SCOPING OPINION:

Proposed Ray II Wind Farm

Case Reference: EN0110031

16 June 2026

Figure 6.1
Landscape and Visual Assessment Study Area

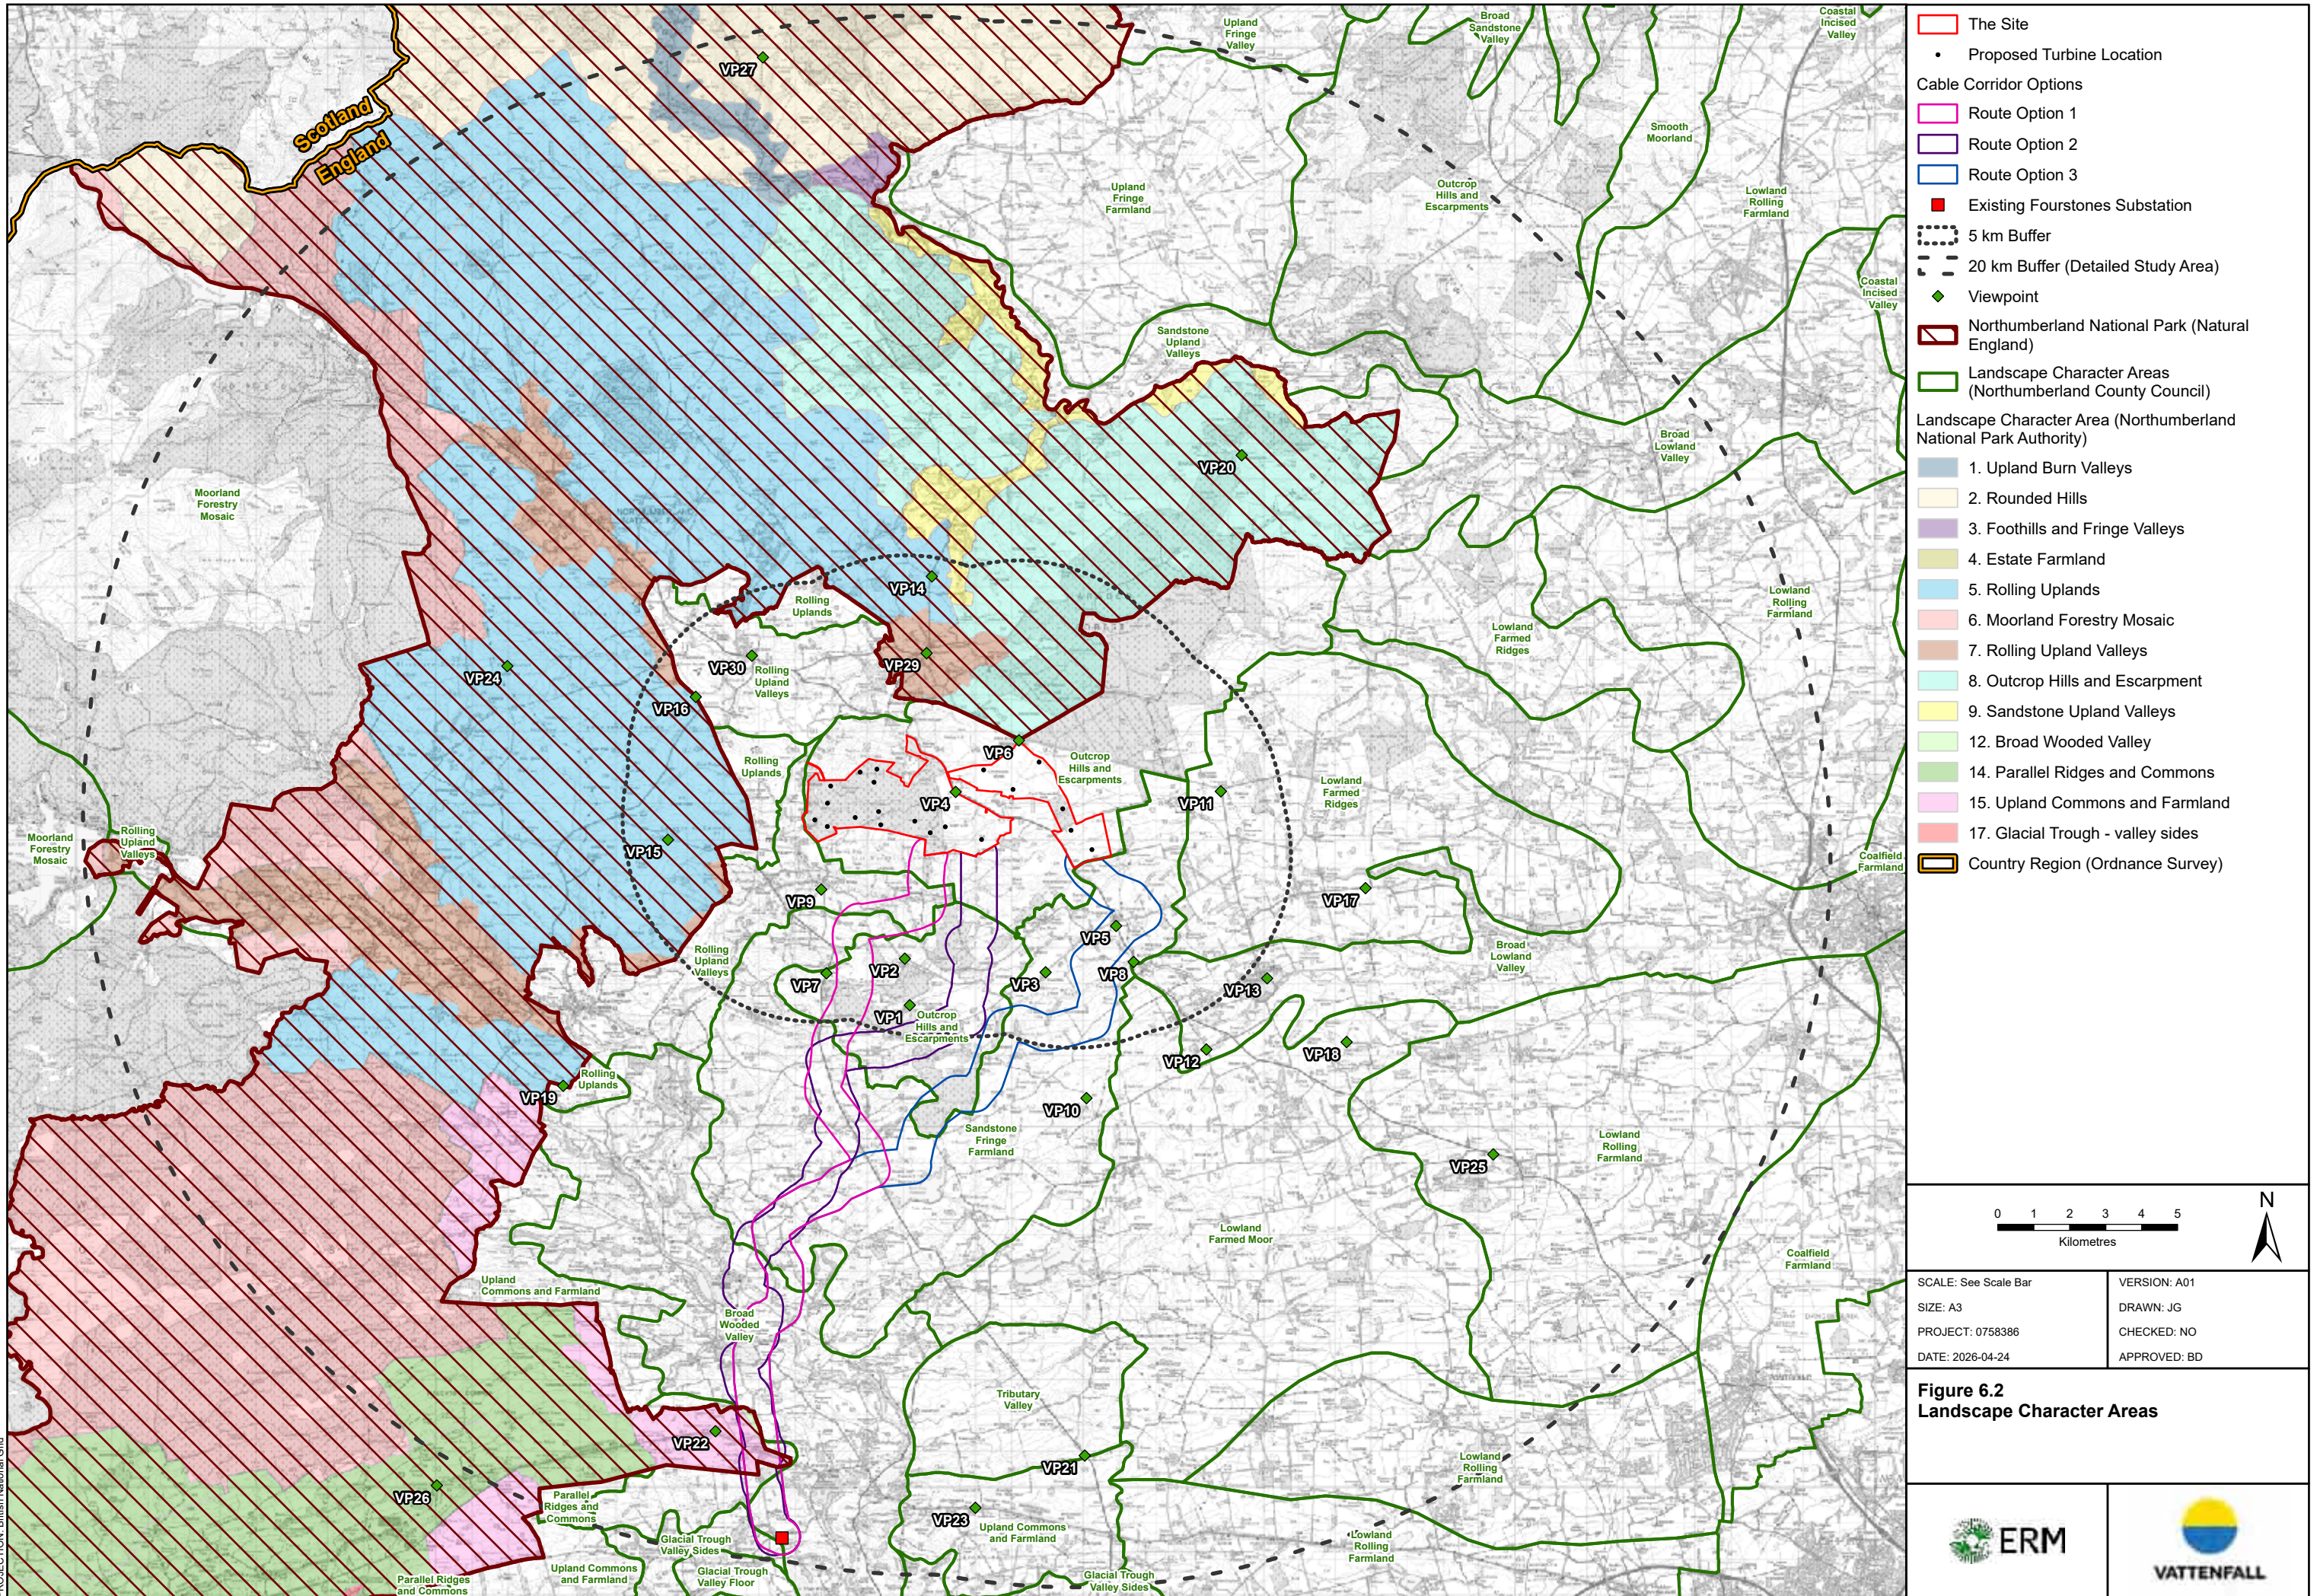
ID	Ref	Description	Inspectorate's comments
3.1.6	Paragraph 6.7.2 and figures 6.1 to 6.6	Study area for cable corridor options	Paragraph 6.7.2 of the Scoping Report proposes a study area of 1km buffer for the cable corridor options. The Scoping Report does not justify why this is deemed suitable and the Inspectorate is concerned that the worst-case scenario would not be assessed in the event that above ground pylons are used for the grid connection. The ES should justify the extent of the study areas used for the assessment of the different cable corridor options with reference to professional guidance and the extent of the likely impacts, informed by fieldwork and relevant models or approaches. A separate ZTV should be provided to assess the potential visibility and effects of cable infrastructure outside of the turbine area. The applicant should agree the study areas with relevant consultation bodies where possible.

Figure 6.4
Viewpoint Location Plan

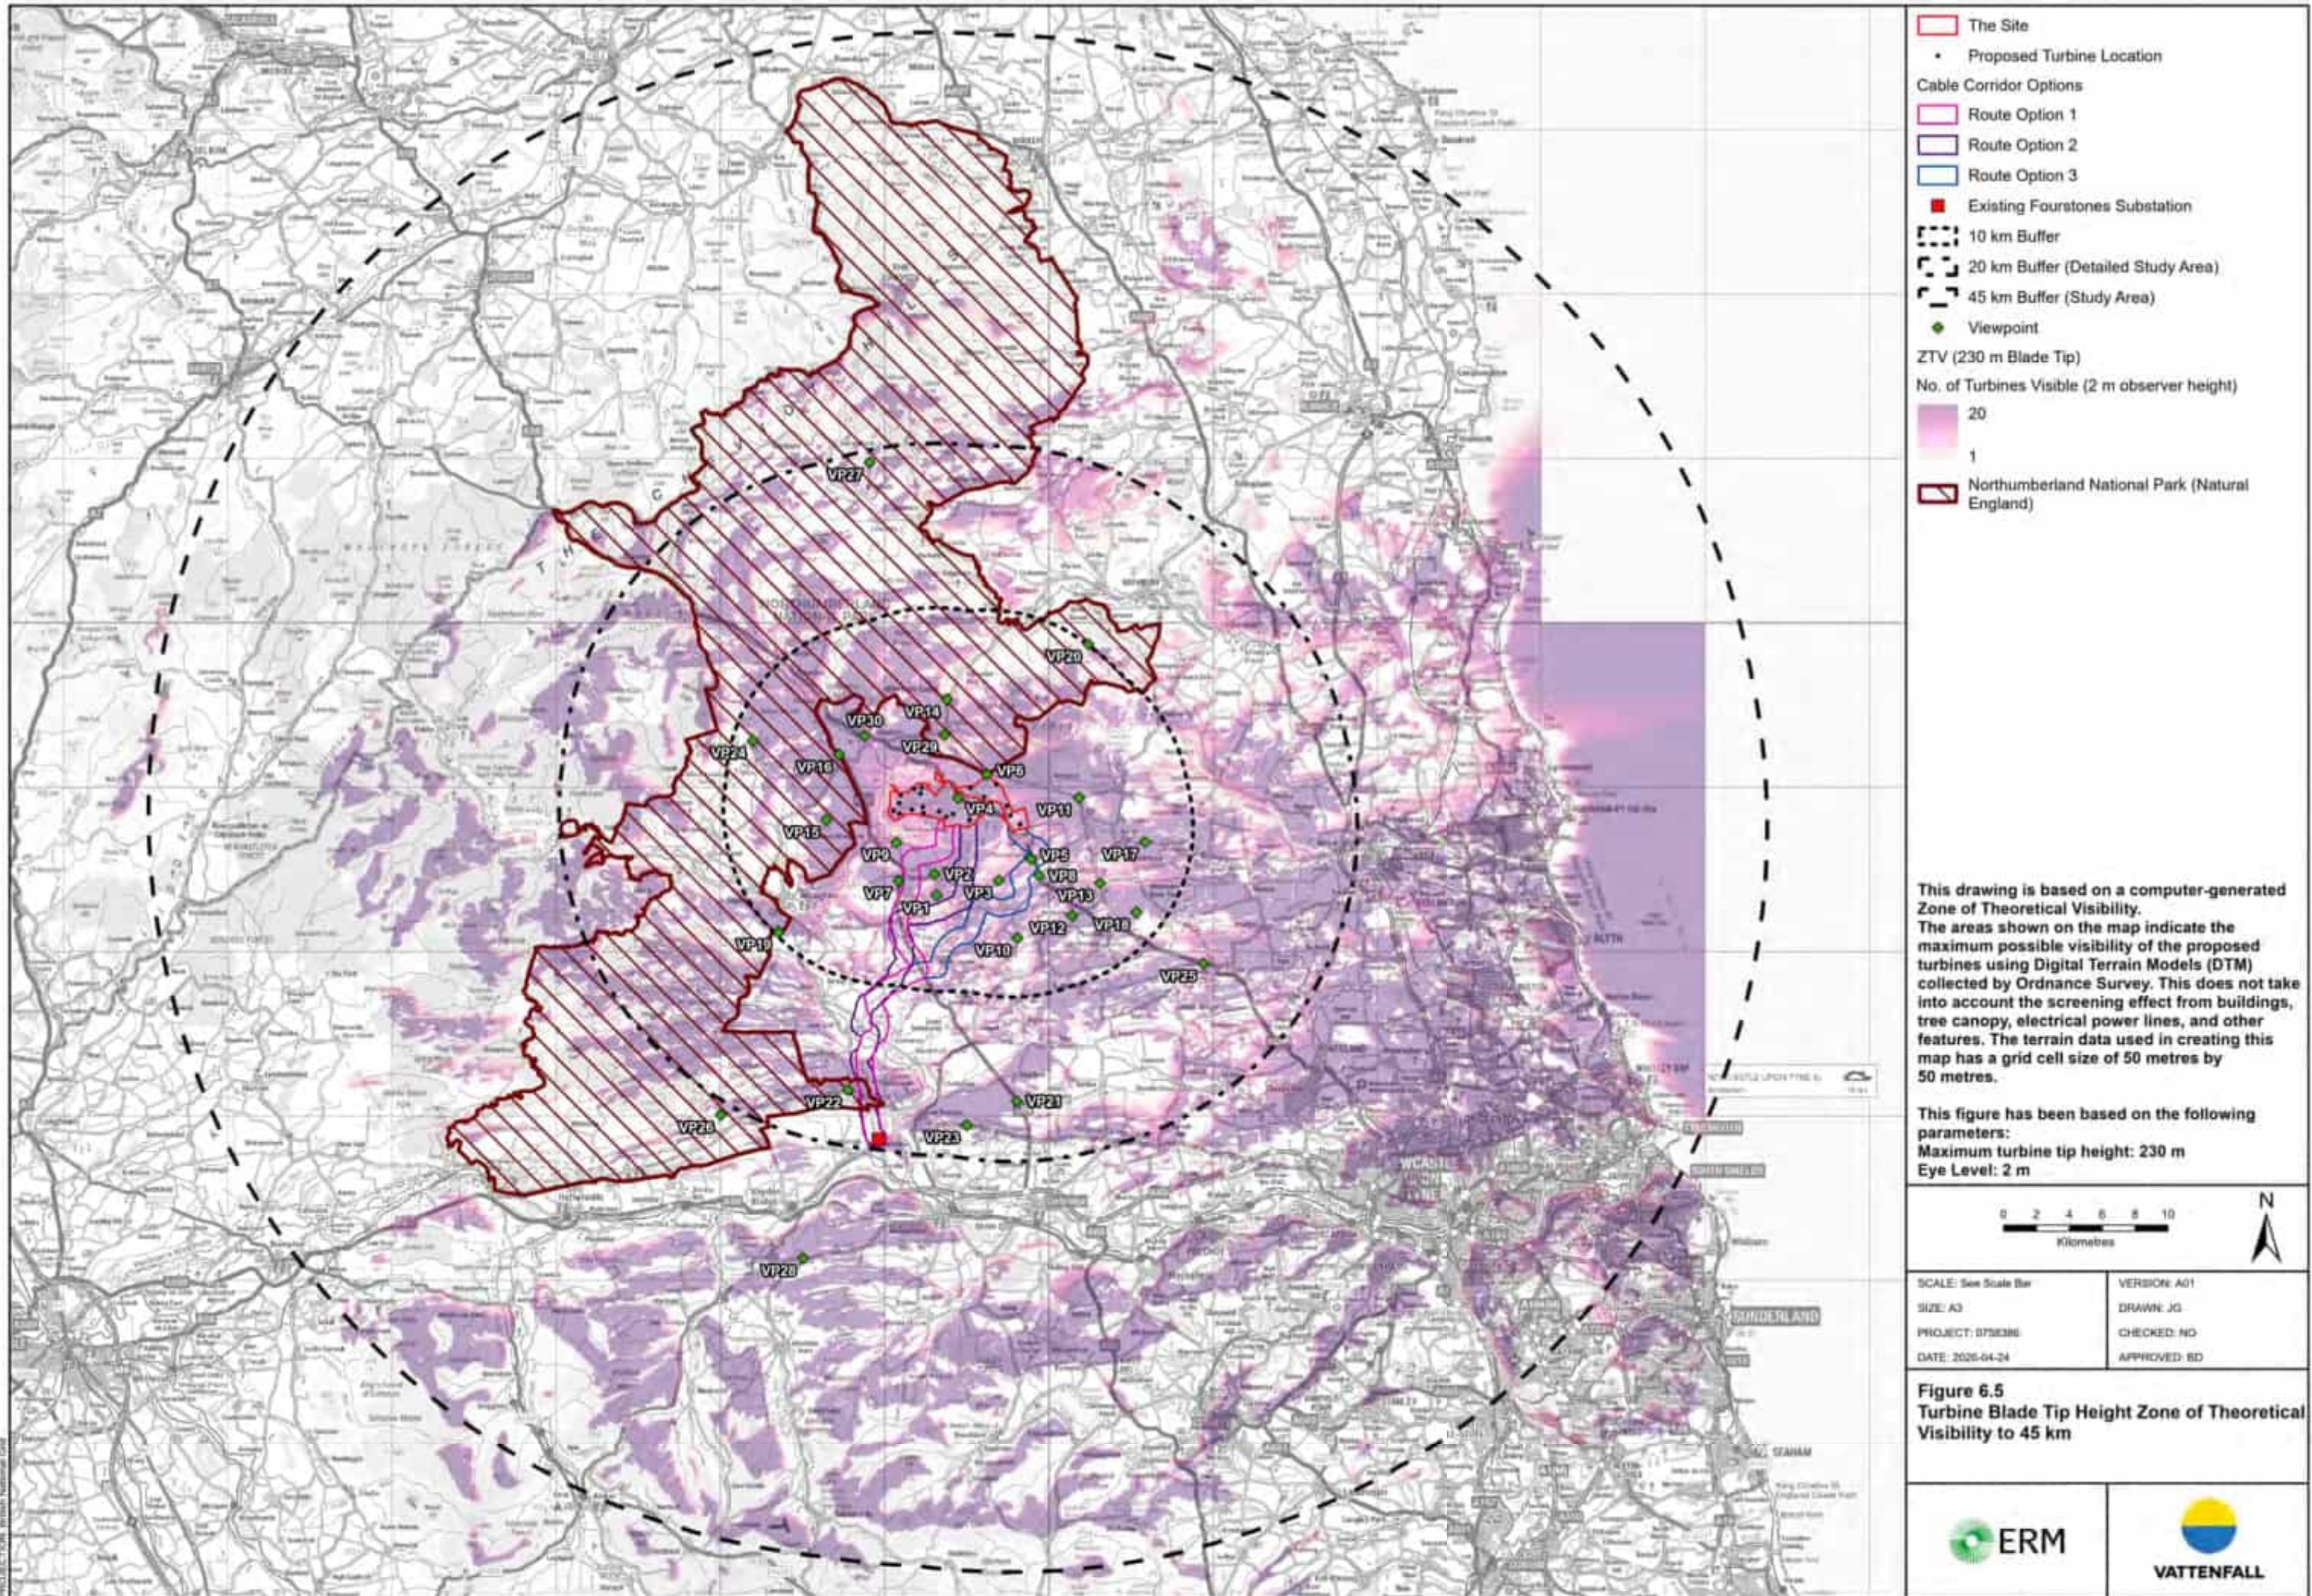
3.1.7	Figure 6.4	Viewpoints	Figure 6.4 of the Scoping Report sets out the viewpoint locations proposed for the Landscape and Visual Impact Assessment (LVIA). The applicant should justify the location and number of viewpoints, ensuring these capture a worst-case scenario of impacts from the proposed development and are representative of visual receptors. Efforts should be made to agree the number and location of viewpoints as well as the locations for photomontages with relevant consultation bodies. The applicant's attention is drawn to the consultation response from Natural England (appendix 2 of this Scoping Opinion) in relation to viewpoint locations.
